# Rezoning Transportation Analysis

Petition Number: 2023-015

## Revision Log:

Date	Description
5-24-23	First Review (JT)
10-26-23	Second Review (JP)
12-20-23	Third Review (JP)

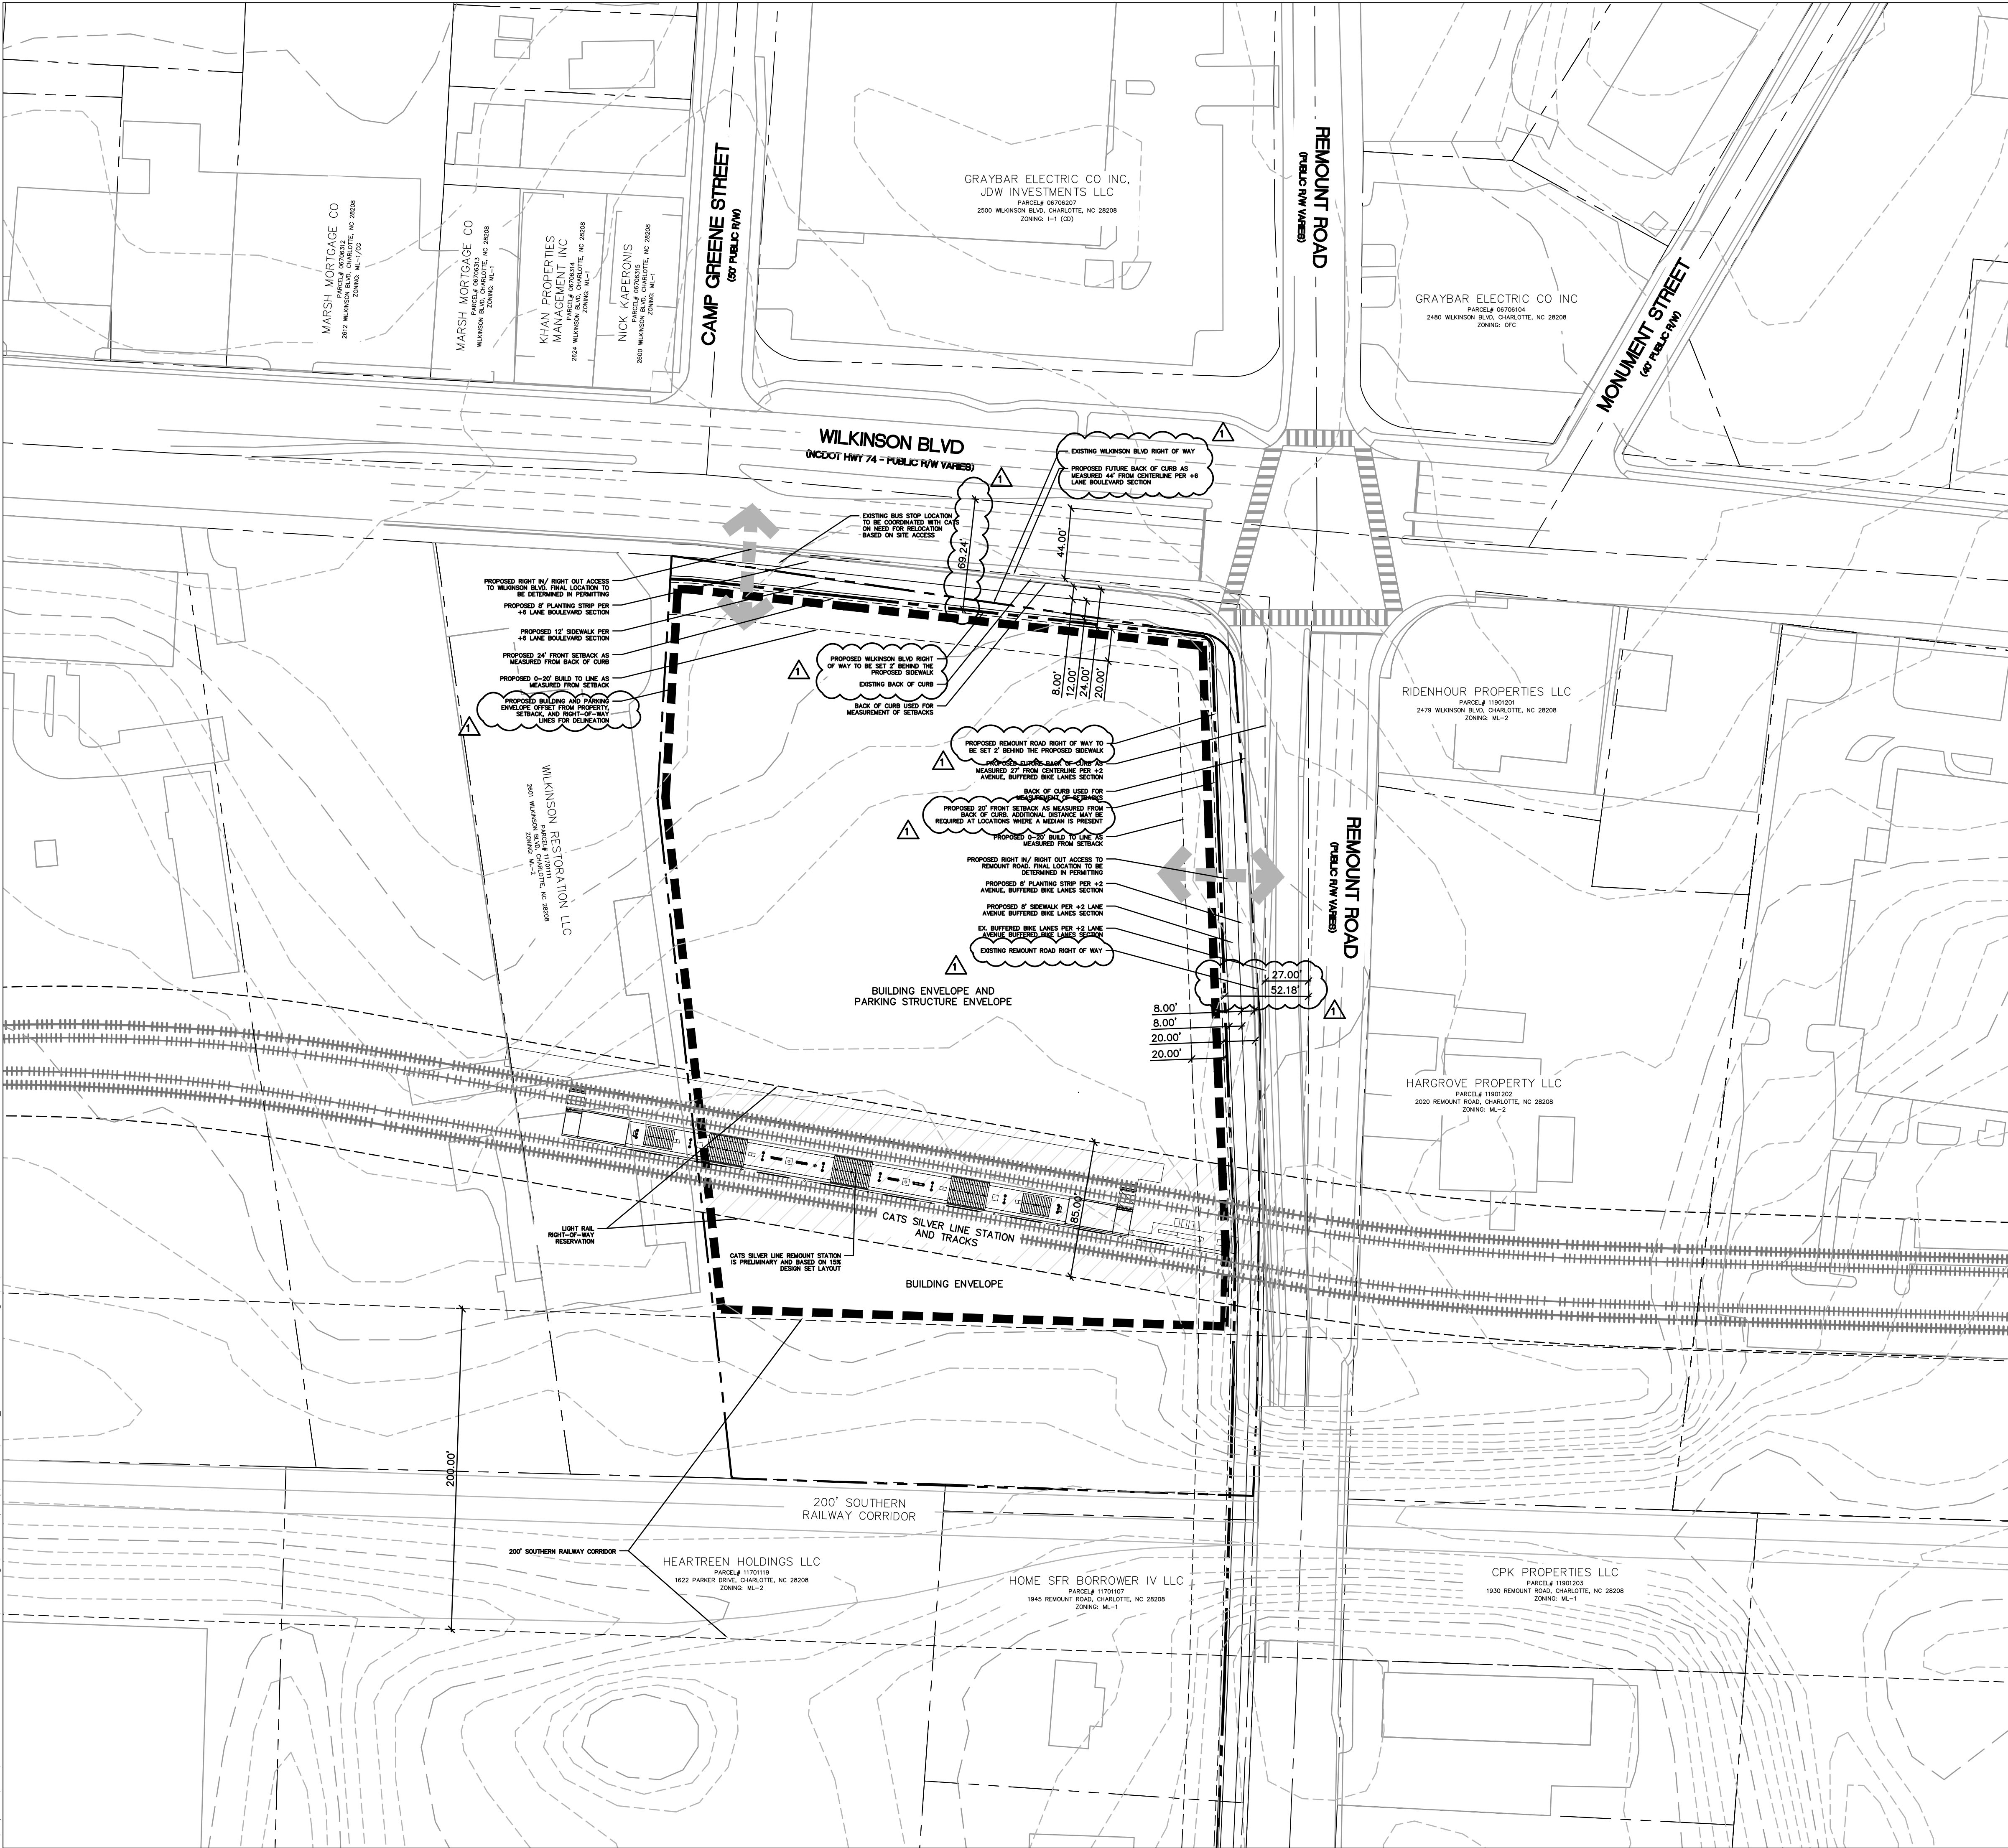
**Outstanding Comment 12.20.23:** Label and dimension the curb and gutter from the centerline for each road on the site plan.

3. Revise site plan and conditional note(s) to label and dimension the right-of-way from the road centerline.
